STORMWATER AUDIT (STAGE 1)

JBA Project Code 2020s1191
 Contract Residential Development– Holybanks, Swords, Co. Dublin
 Client Cairn Homes Properties Ltd.
 Date 05th October 2020
 Author Jamie Cullen
 Subject **Stormwater Audit - Stage 1 Report**

JBA Consulting Stormwater Audit - Stage 1 Feedback Form	
Project:	Residential Development at Holybanks, Swords, Co. Dublin
Date:	05/10/2020
JBA Reviewers	Jamie Cullen - Assistant Engineer
Project Number:	2020s1191

CLIENT	CARN HOMES PROPERTIES LTD.		
ARCHITECT	MCORM ARCHITECTS		
PROJECT	SHD AT HOLYBANKS, SWORDS		
TITLE	PROPOSED DRAINAGE LAYOUT (SHEET 1 OF 4)		
DRAWN PW	DESIGNED LRG	APPROVED EC	DATE MARCH 2022
SCALE 1:500 @ A1	JOB NO. 17-088	DRG. NO. P200	REVISION -

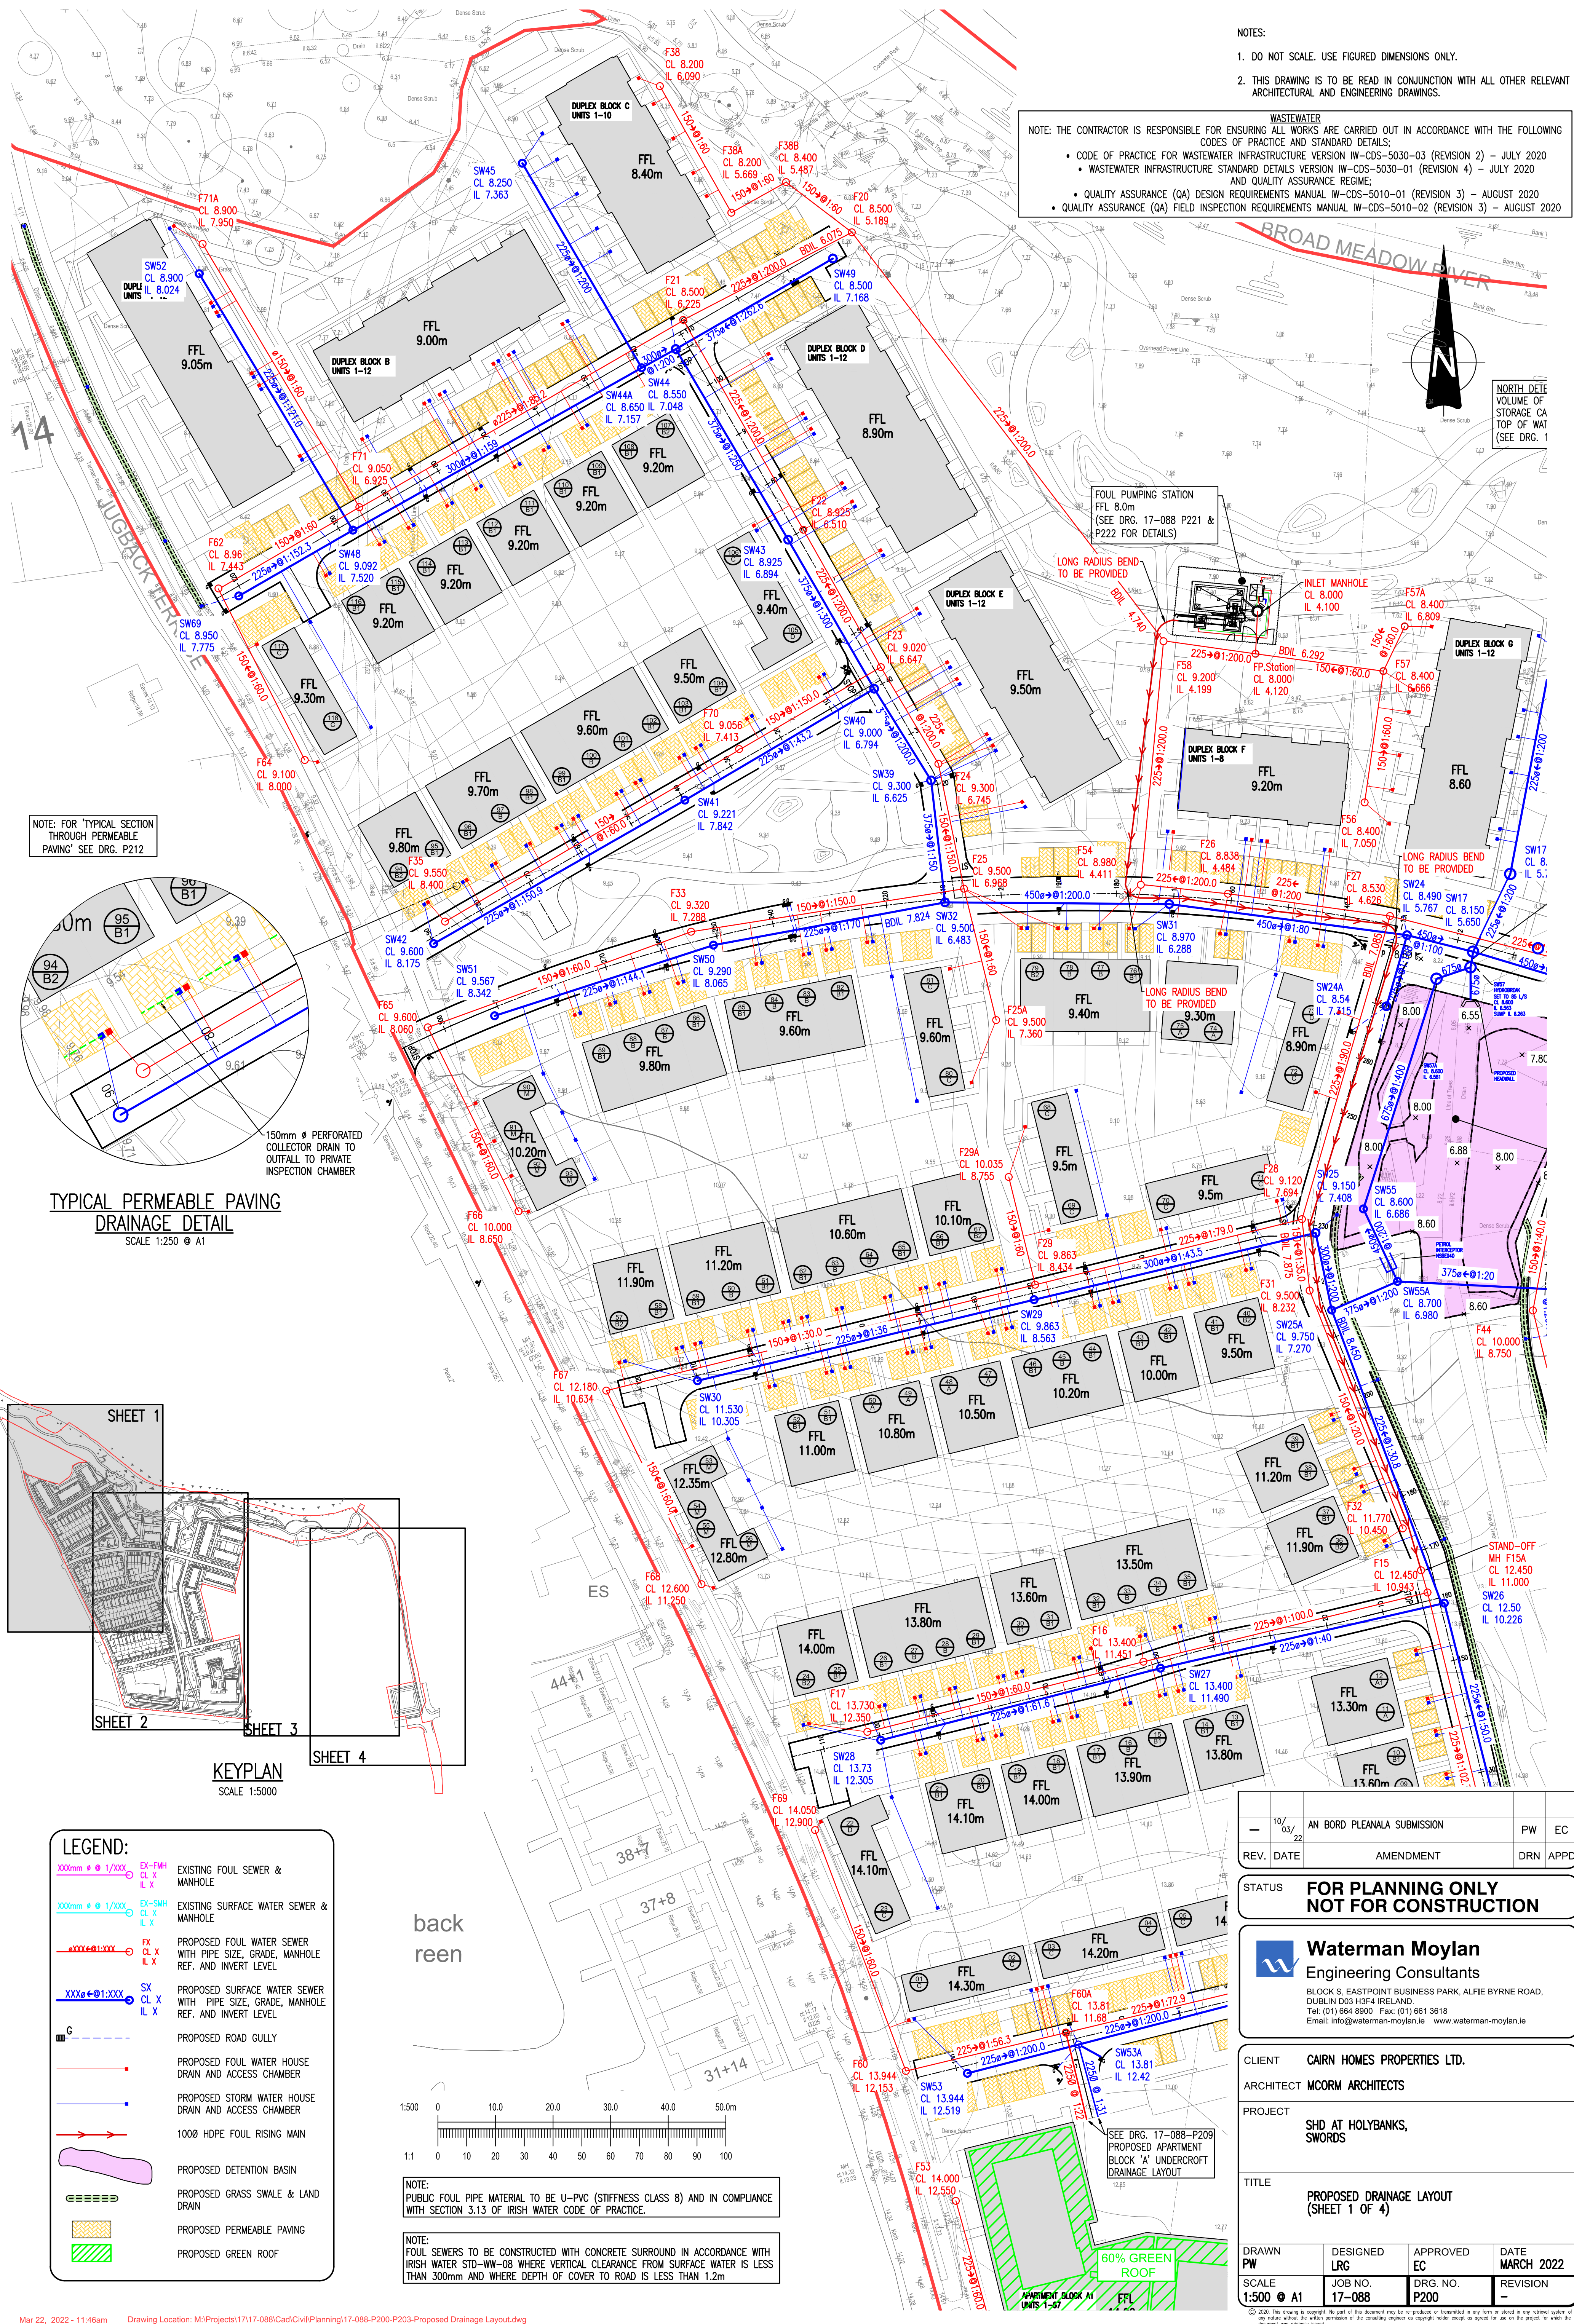
11	In the FLOW output the Hydro-brake invert levels do not match the invert levels shown on drawing P200 & P201. There is also 4 Hydro-brakes within the calculations compared 3 displayed on the drawings.	Waterman Moylan to review and advise.	Hydrobreaks have been amended. There is a 4th Hydrobreak in the model in order to model an additional 2l/s flow from the future school.	Acceptable
12	Snr swales are shown on the drawings throughout the site for road interception. However, as no road gullies are shown, it is unclear if the subject road(s) have a cross fall towards the swales where no kerb is provided.	Waterman Moylan to review and advise.	We can confirm that at the location of the swales the roads will be constructed with a road fall towards the swales as can be seen in the details drawing 17-088-P211 and 174-088-P190.	Acceptable
13	<p><u>Interception</u> Whereas some access roads are intercepted by the provision of swales, other access roads are not.</p>	Waterman Moylan to review and consider other local SuDS measures to provide local interception of all hardstanding surfaces.	Where swales are not provided, gullies and permeable paving will redirect water into the system. Refer to attached updated drawings 17-088-P200/P201.	See Note 23

CLIENT	CARN HOMES PROPERTIES LTD.		
ARCHITECT	MCORM ARCHITECTS		
PROJECT	SHD AT HOLYBANKS, SWORDS		
TITLE	PROPOSED DRAINAGE LAYOUT (SHEET 2 OF 4)		
DRAWN PW	DESIGNED LRG	APPROVED EC	DATE MARCH 2022
SCALE 1:500 @ A1	JOB NO.	DRG. NO. P201	REVISION

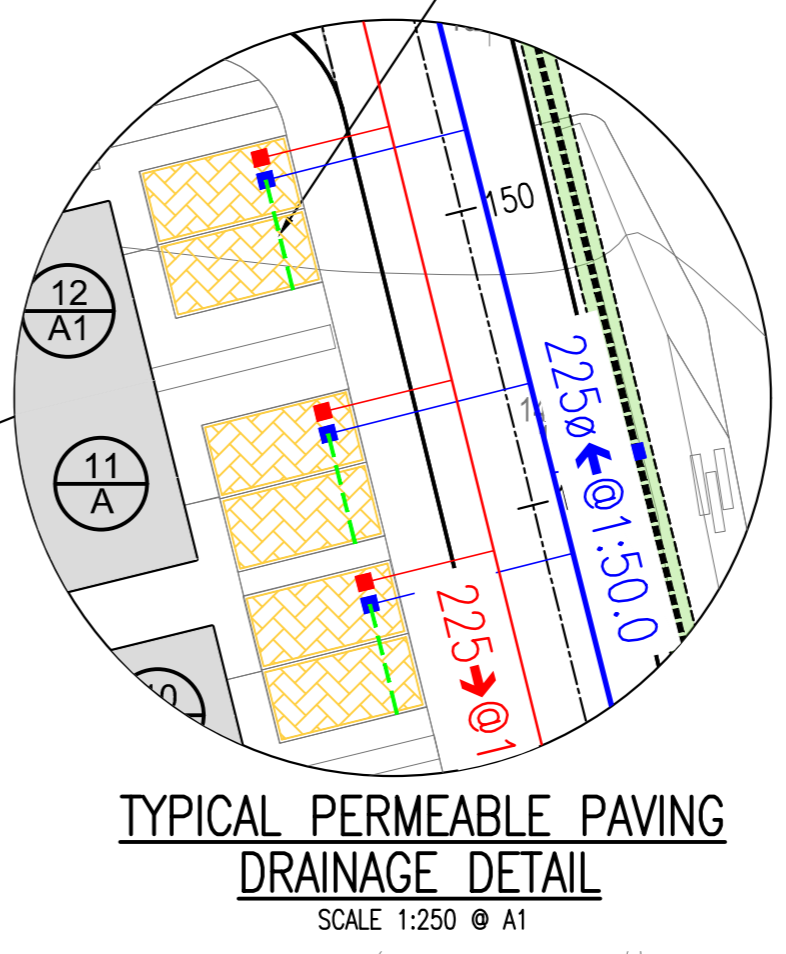
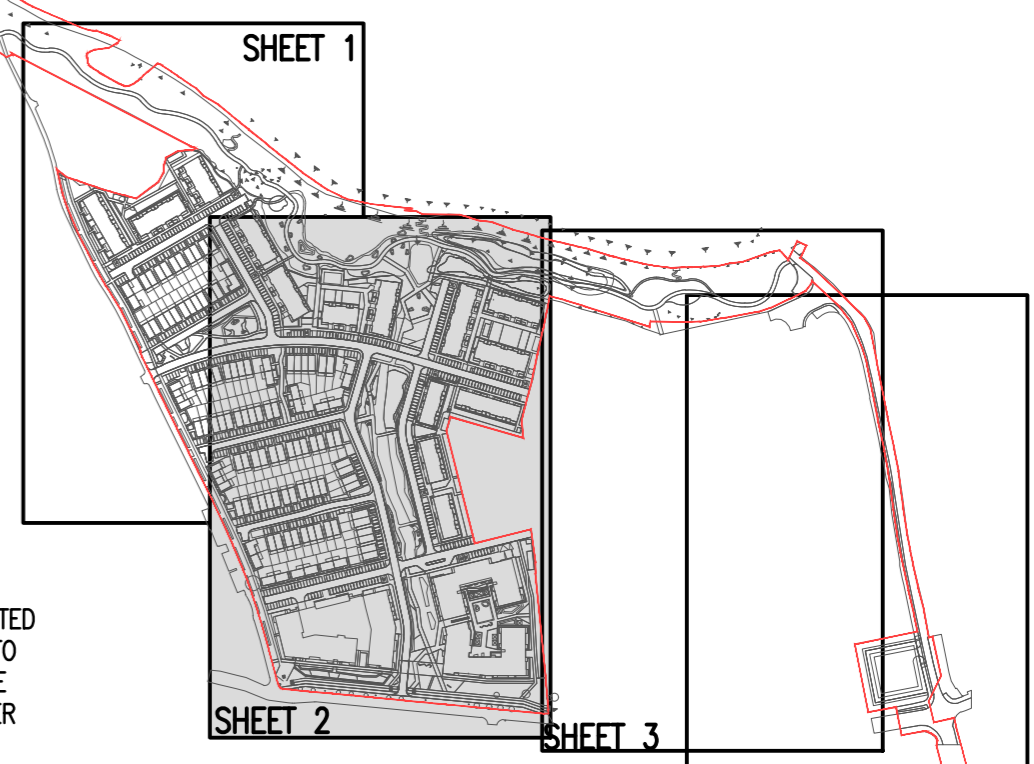
4	<u>Drainage Drawing Nr P201</u> It is noted that the invert level of the northern detention basin is 6.1m with an overall flood depth of 0.8m giving a top water level of 6.9m. However, this only provides 100mm freeboard above the proposed FFL's of 7m and as per the GDSDS, this should be a minimum of 0.5m. In addition, the top water level is the same level as the top of the side slopes around the basin with no freeboard provided.	Waterman Moylan to review	Refer to updated drawings 17-088-P201 and P211. A minimum 0.5m is now proposed between the flood top level and the FFL's of Duplex blocks I and H. Additionally, a 0.3m freeboard is proposed for the North Detention Basin.	Acceptable
5	<u>Drainage Drawing Nr P201</u> Further to item 4 above, there are no details provided to indicate the top water level within the central detention basin. Proposed levels would suggest insufficient freeboard is provided given the proposed apartment block with a FFL of 7m to the north-east corner of the detention basin.	Waterman Moylan to review	Central detention basin has been amended and will store 620 m3 for the 100 year storm + 20% Climate change. The total storage of this basin is approximately of 900m3, allowing for a total freeboard of 230mm in line with section 6.3.2.1 of GDSDS.	See Note 20

6	<u>Drainage Drawing Nr P201</u> The proposed levels to the central detention basin would suggest storm manhole SW55 is exposed.	Waterman Moylan to review	Manhole cover level amended. Please refer to updated drawing 17-088-P201.	Acceptable

TITLE **DETENTION BASIN DETAILS**

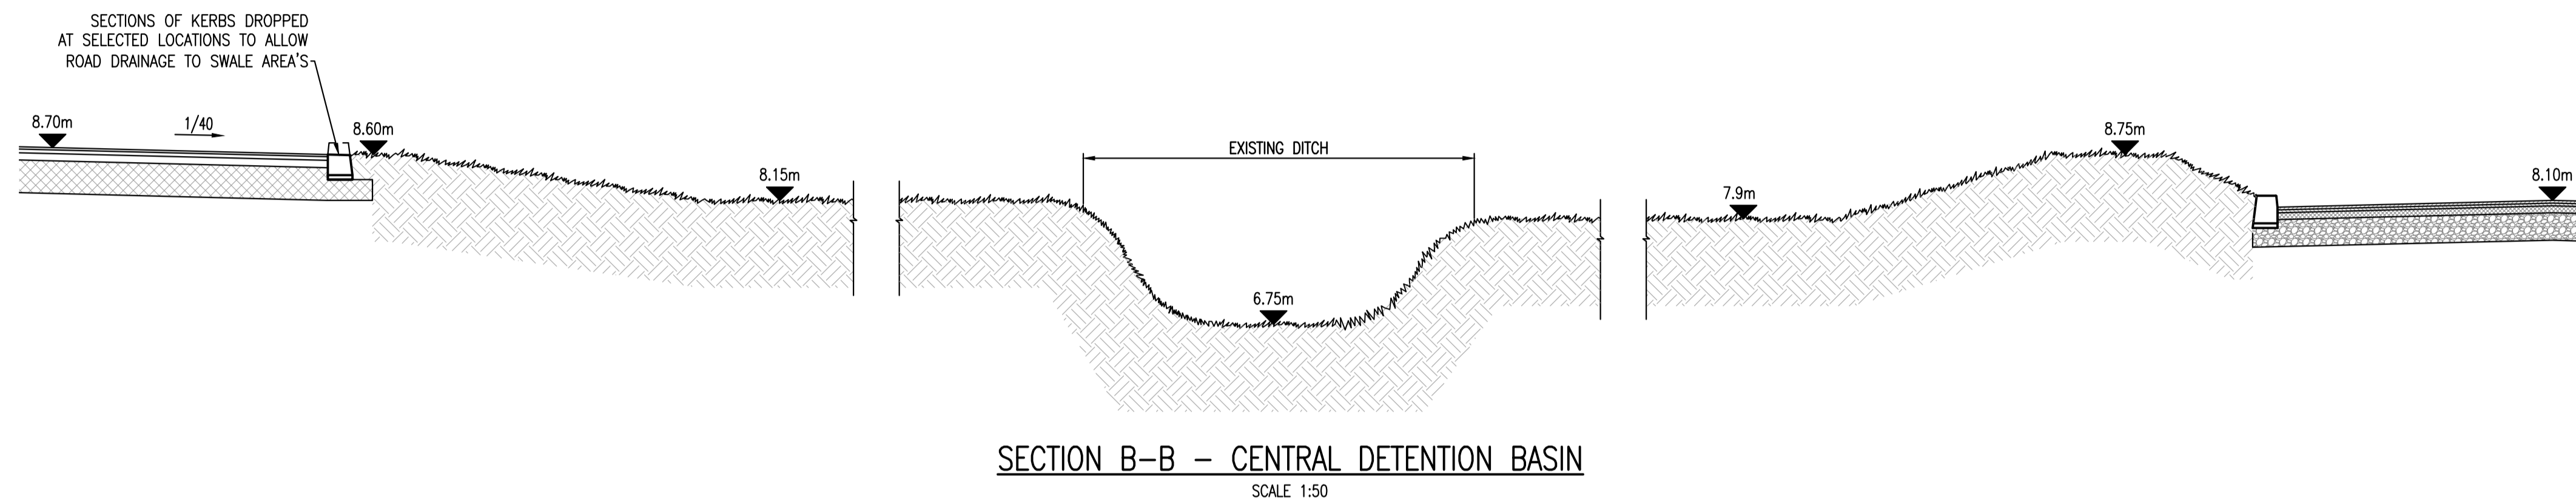
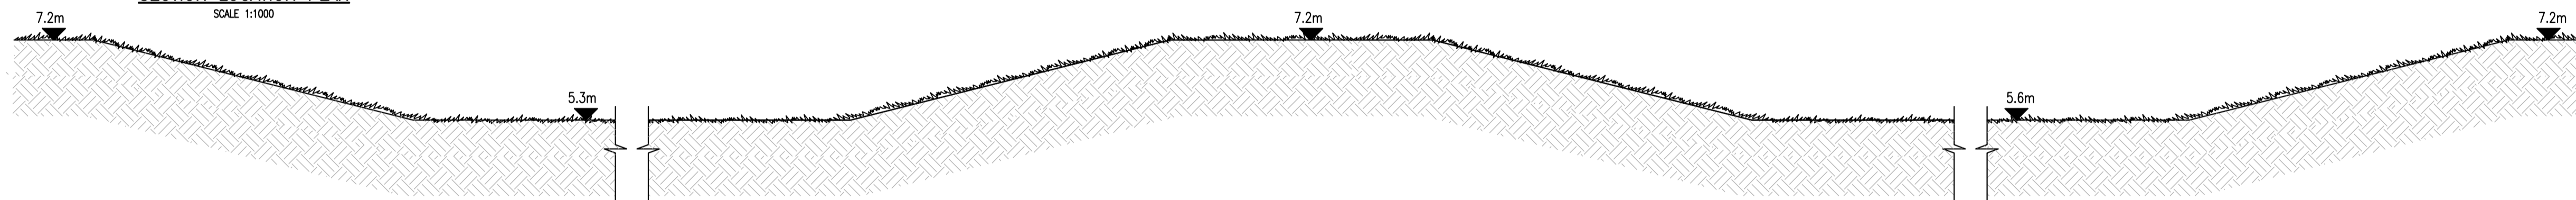
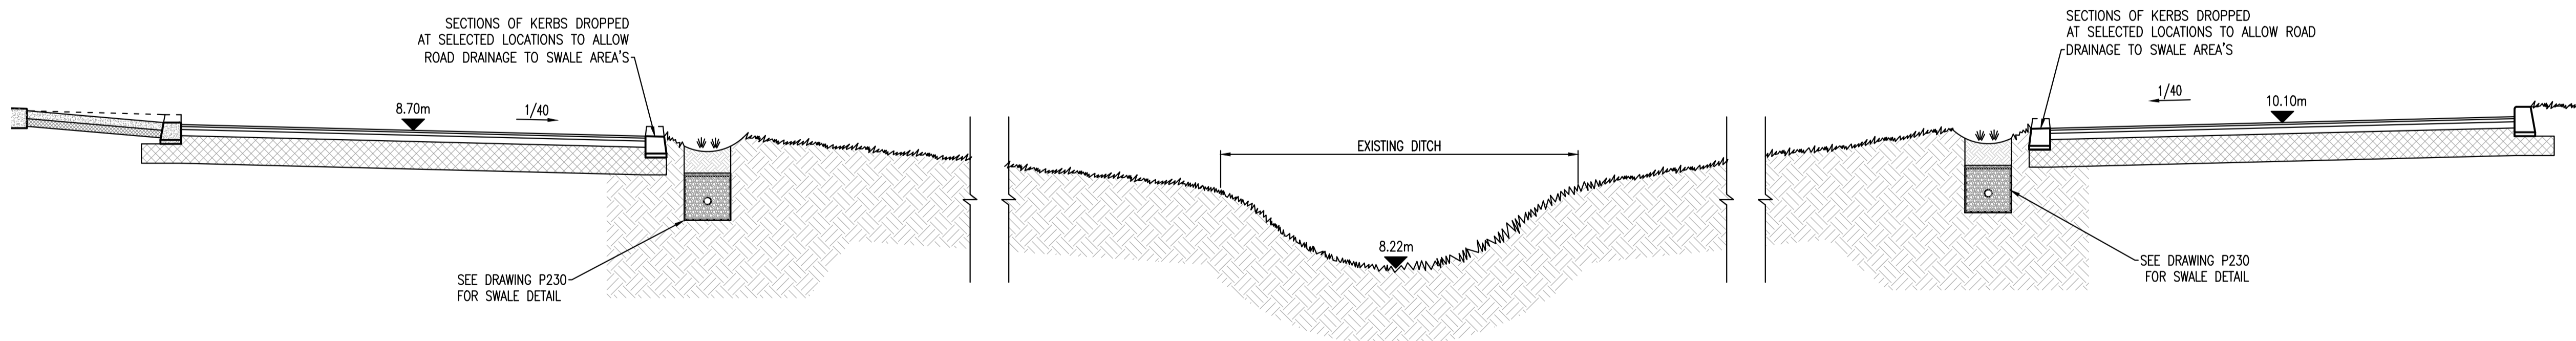
25/01/2021				
20	<p>Section 6.3.2.1 of the GSDS on the Storage Pond Flooding states that <i>"Storage pond water levels are designed specifically, and therefore there is less uncertainty than for river flood water levels. However, property floor levels must be provided with a safety freeboard and it is recommended that this is 500mm."</i> <i>"The design of overflow structures for a 200 year event and still providing a freeboard of at least 200mm."</i> The minimum freeboard from TWL to FFL should be a minimum of 500mm not 200mm.</p>	Waterman Moylan to review and advise.	<p>Central detention basin - Top of storage level in detention basin - 8.305m OD Malin - Lowest FFL - 8.60m OD Malin, we would note this detention basin does not have the required separation distance of 500mm however, the unit in question is adjacent to a road at gradient of 1/20, this will direct water flow away from the unit before it ever reaches a level of 8.60m, the adjacent road is at a level of 7.6m on the northern boundary of the unit in question, 1m lower than the unit level therefore risk of flooding from this detention basin into said unit is extremely unlikely and not an issue. North detention basin - Top of storage level in detention basin - 6.824m OD Malin - Lowest FLL - 7.4m OD Malin</p>	Acceptable
